Olympic Vista PRD
File No. PA22-044
PCS Job No. 21-2494

1st Review Response Letter

A.F. NO. _____ SHEET 1 of 3

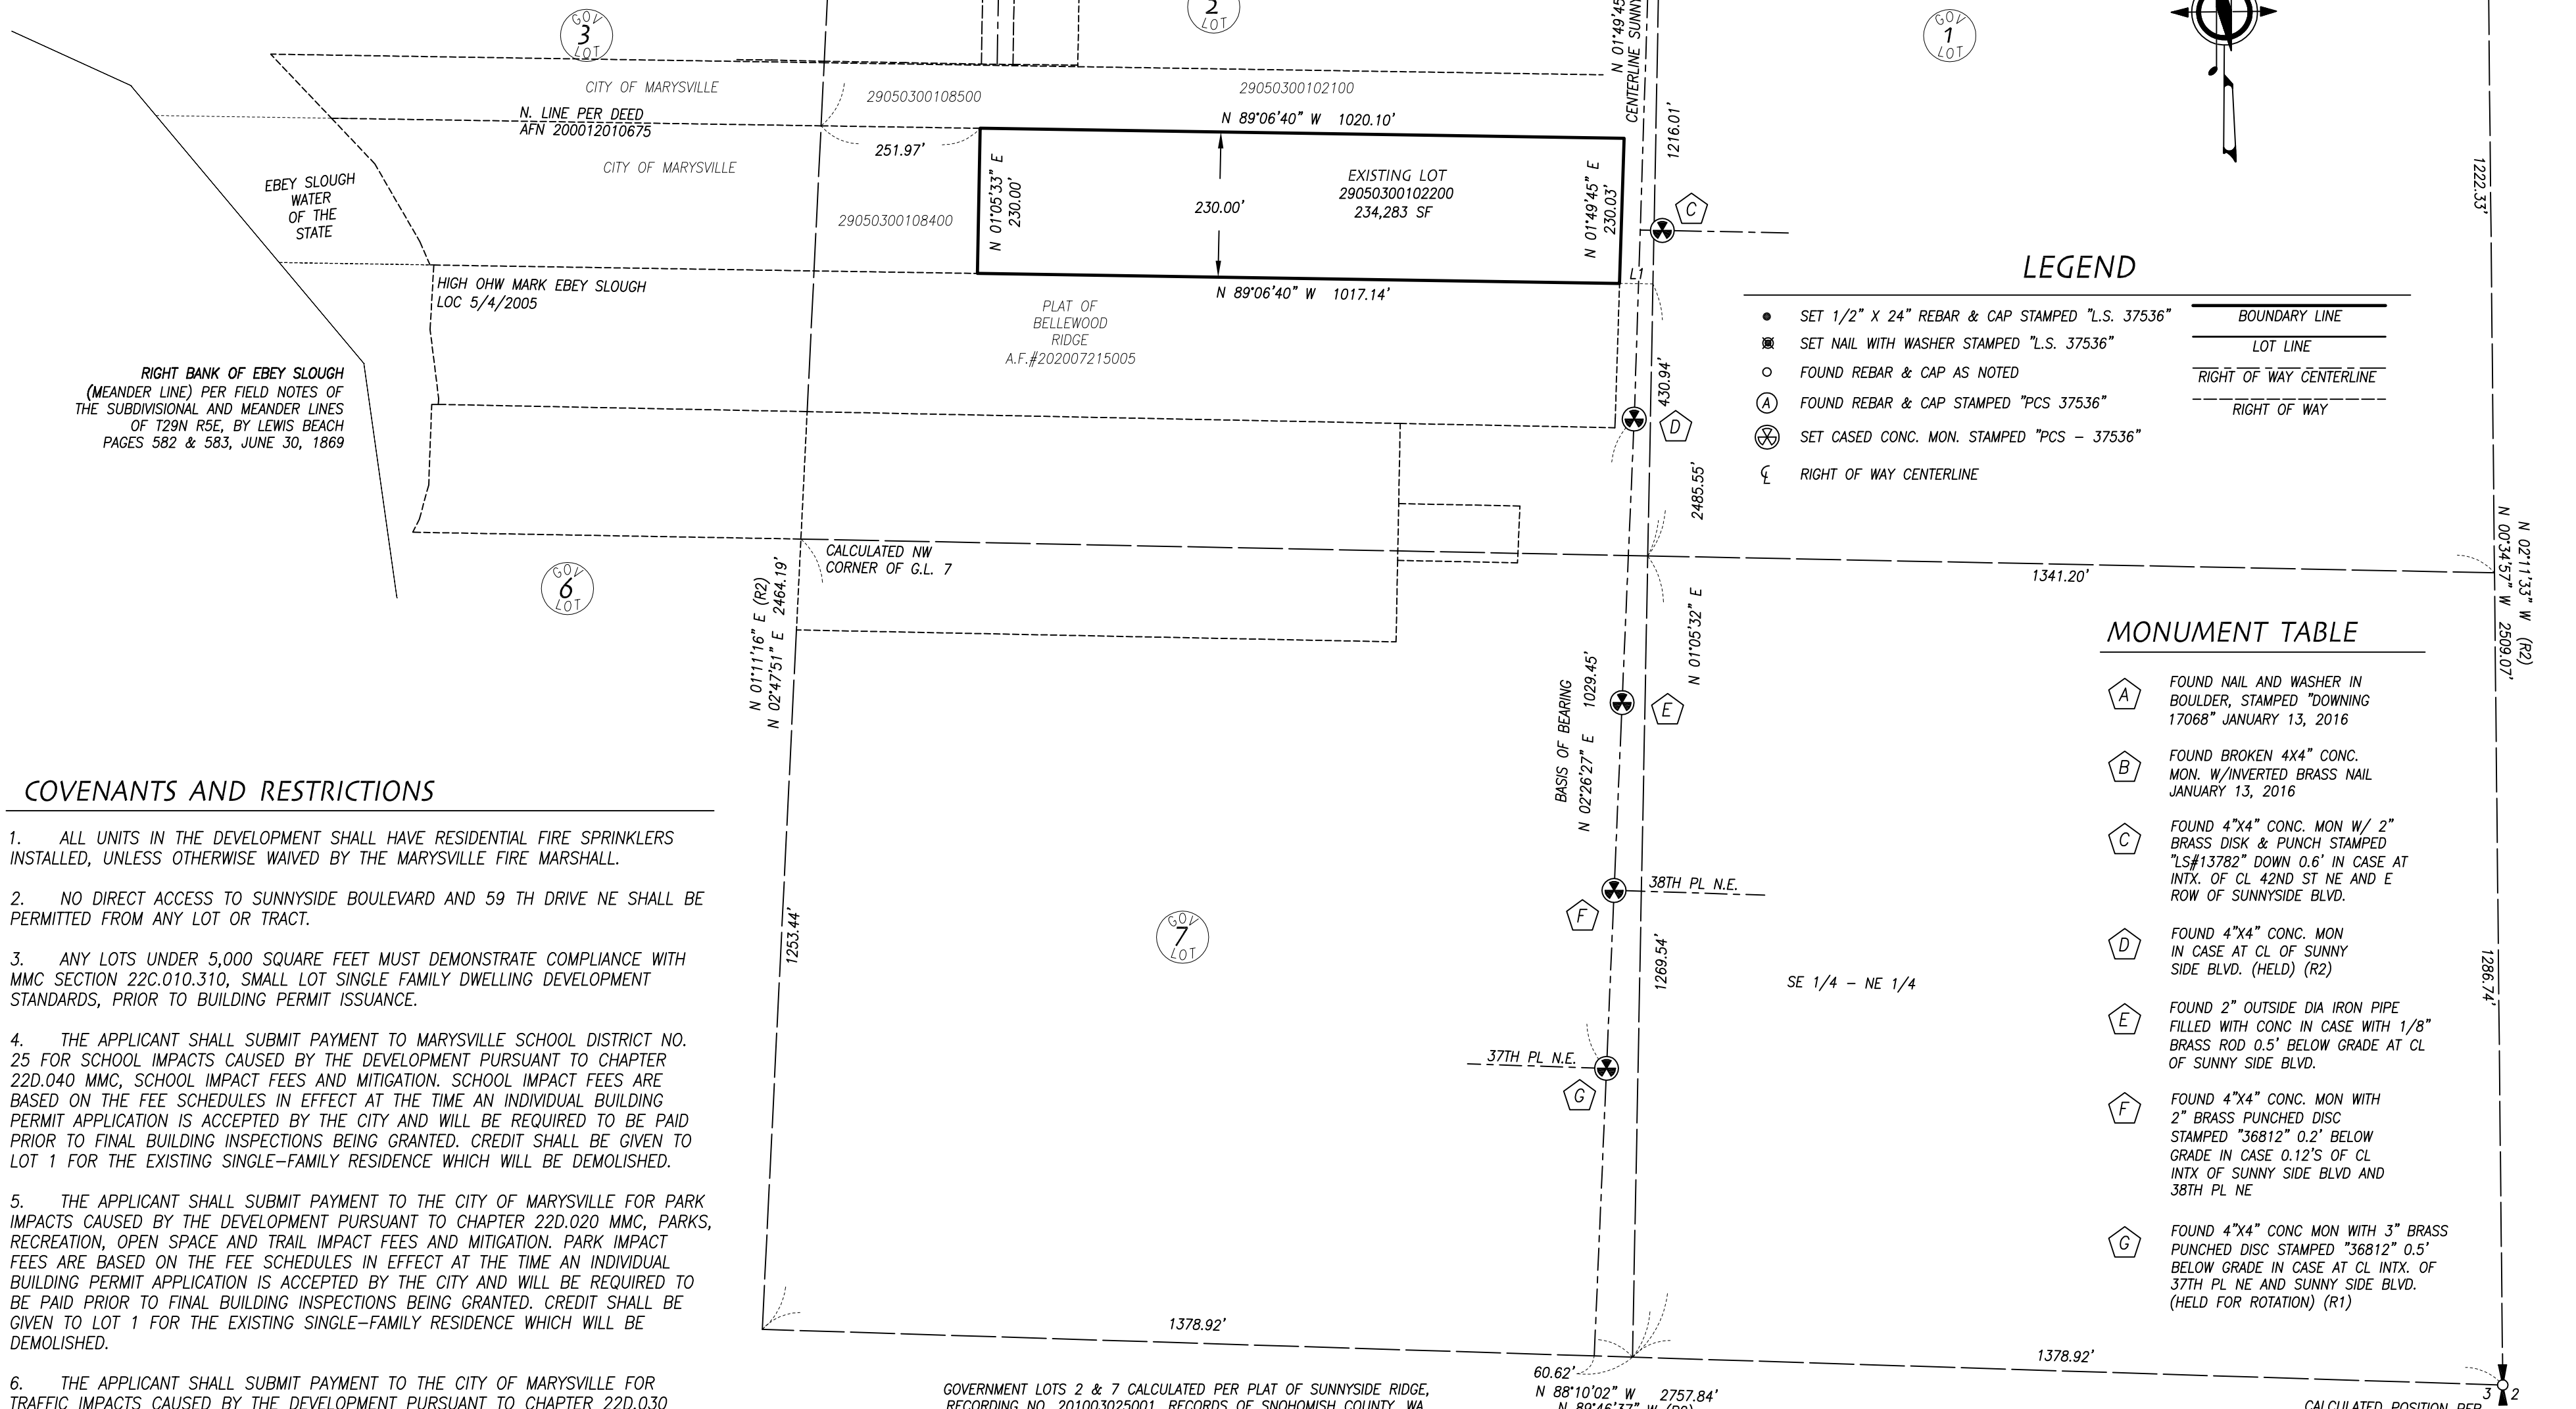
1. Noted.
2. Lot 11 and Tract 998 have been revised, closure calculations v2 included in 2nd submittal.
3. Legal description revised on sheet 1.
4. Building setback line left as-is per email from the city dated October 2, 2023, at 2:53 PM.
5. Corner monuments now shown on sheet 3.
6. Language added on sheet 1.
7. Traffic Impact fees restriction added on sheet 2.
8. ADU restriction not added per email from the city dated October 2, 2023, at 2:53 PM.
9. Space for recording number included in 1st submittal on sheet 1 in the Dedication.
10. Restriction added on sheet 2.
11. Restriction added on sheet 2.
12. Noted.
13. Septic decommission invoice included in 2nd submittal.
14. Engineer letter included in 2nd submittal.
15. CC&Rs included in 2nd submittal.
